Response to Planning application from Hertfordshire County Council (T and CP GDP Order 2015)

District ref: 6/2018/0041/FULL

The Listed Hangar

Extension of staff car parking facilities to provide an additional 27 spaces.

PROPOSED  
 SITE PLAN (PART)

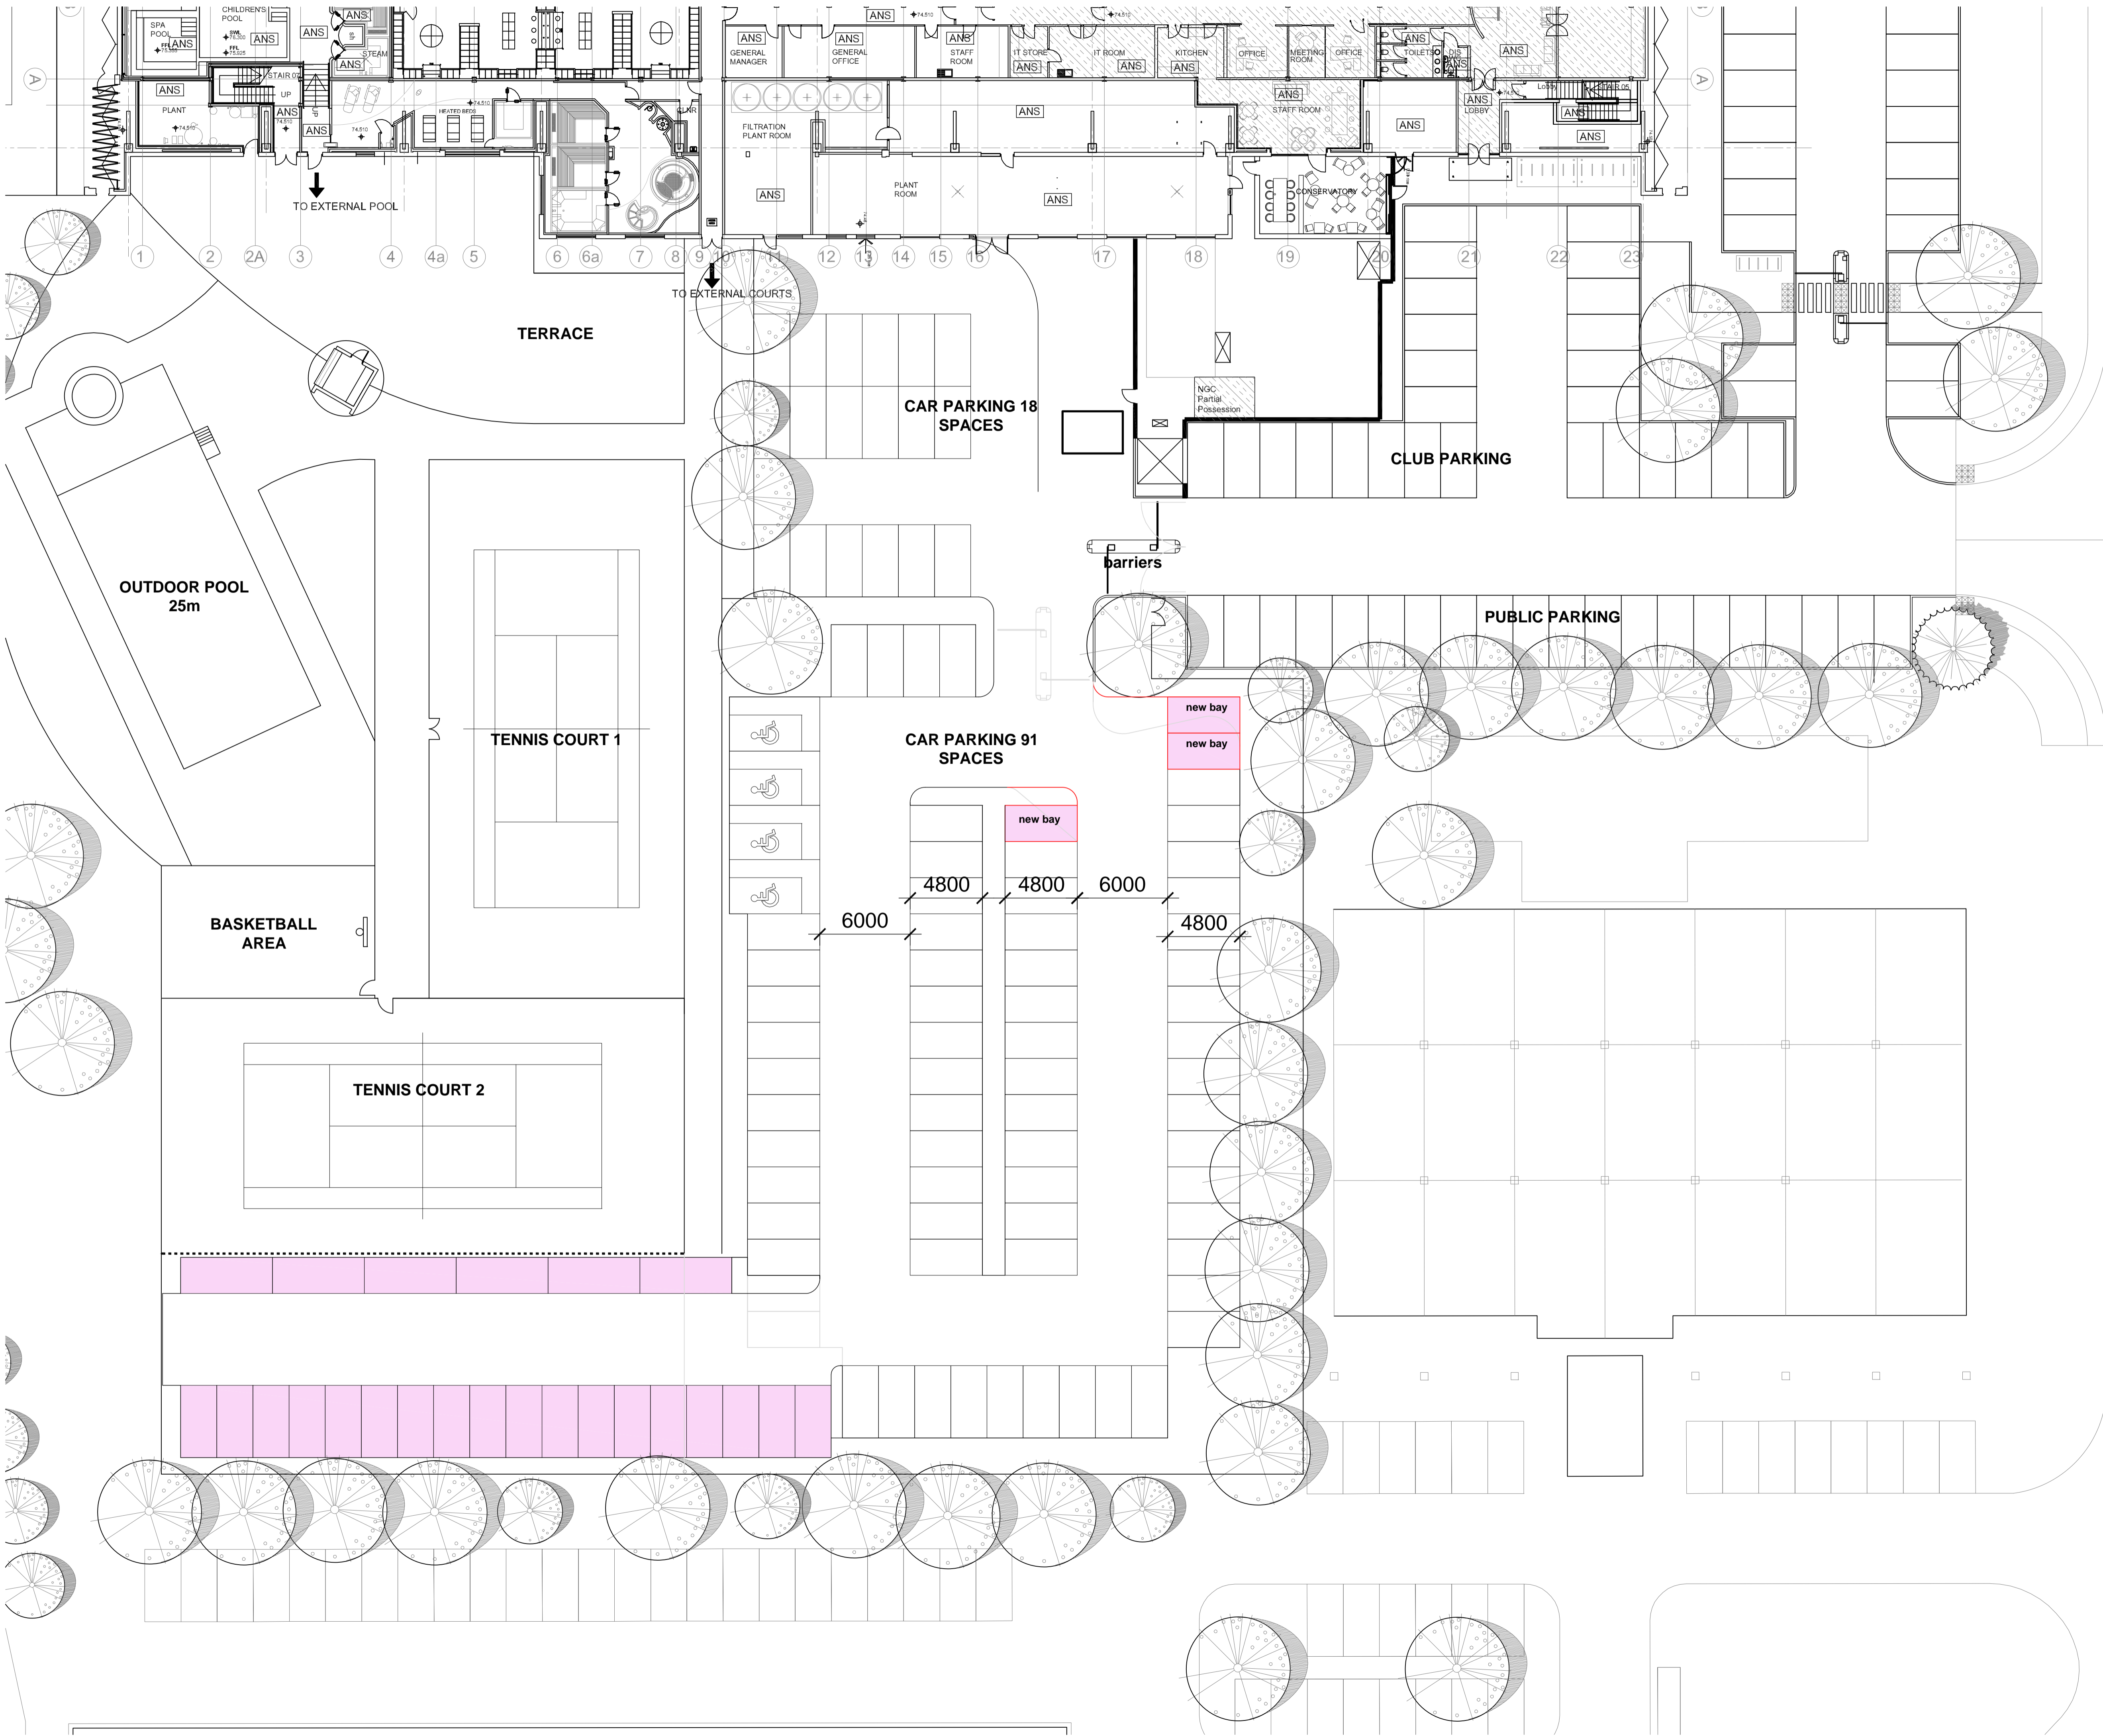
The layout of the additional spaces is in effect a continuation of vehicle parking spaces, the spaces are set out with a suitable 6 meter maneuvering space, and each space is of an acceptable dimension of 2.4 meters by 4.8 meters. 6 of the proposed spaces are arranged as paralleled bays, and are 6 meters in length allowing full use.

Provision is only of standard parking bays, no increase of accessible parking is detailed, the LPA may wish to review the total provision and accessible provision.

The proposal is within the SPG parking standards as such would not represent a severe impact to highway capacity, the design and layout of the provision is to standard dimensions and unlikely to represent a safety risk to internal movements or highway users. The Highway authority present no objection to the proposed development.
